July 19, 2021

RE: Agency Review Comments from EDARP – Falcon Meadows at Bent Grass Filing No. 1

File Nos.: SF-21-020

# FALCON MEADOWS AT BENT GRASS

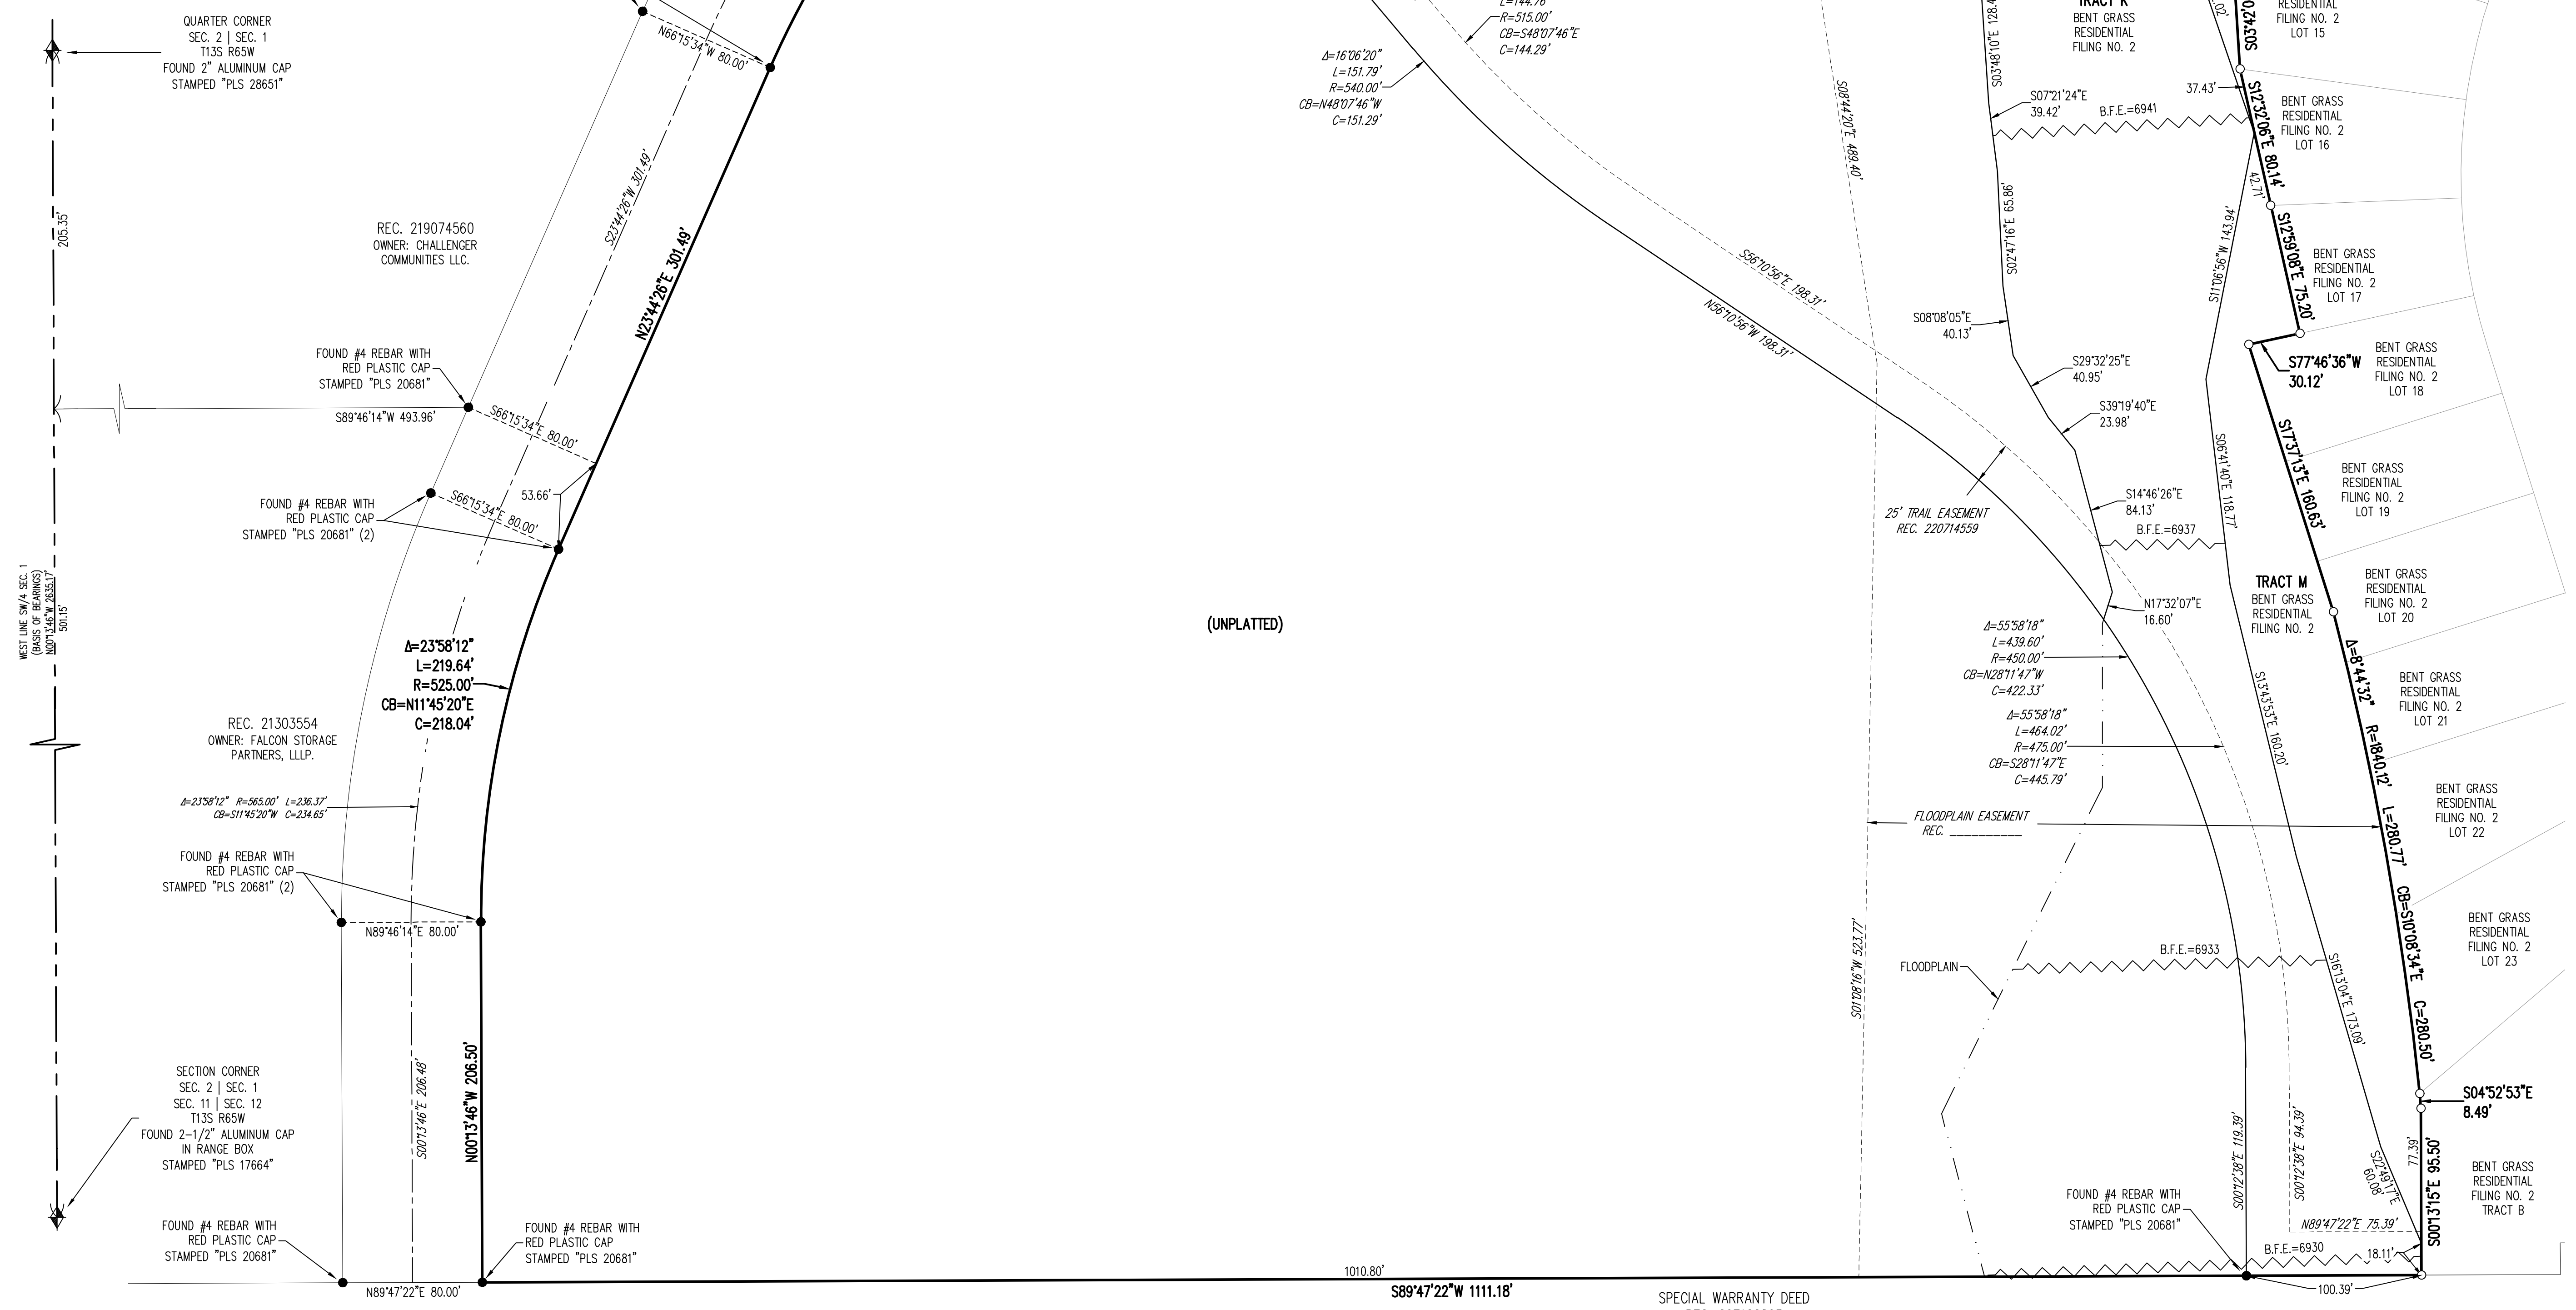
PCD Project Manager State Summary Form: legal is different on the sub summary form, loi. Also, the lots adjacent to the drainage and 7 acre park site are not shown on plat, but are in the LOI...Are you converting the lots depicted on the PUD to open space per the plat tract table, or are you creating a future development tract ? Is 71 lots accurate? 6/9/2021 9:23:14 AM

PCD Project Manager The plat states a different acreage in the legal (18 acres) as does the legal in Word than the LOI, application and Sub summary form (21 acres). 6/9/2021 9:16:39 AM

PCD Project Manager Plat Planner comments only. Please view the latest PUDSP 20 005; The plat should match. 6/8/2021 5:27:48 PM

1.Addressing has been provided, place the addresses on the plat.

Response: This filing does contain 71 lots. Area of Filing has been updated on various forms (Area is 21.31 acres)

Response: Items have been updated to reflect the 21.3 acres.

Response: Plat has been updated.

Response: Addressing has been included on plat.
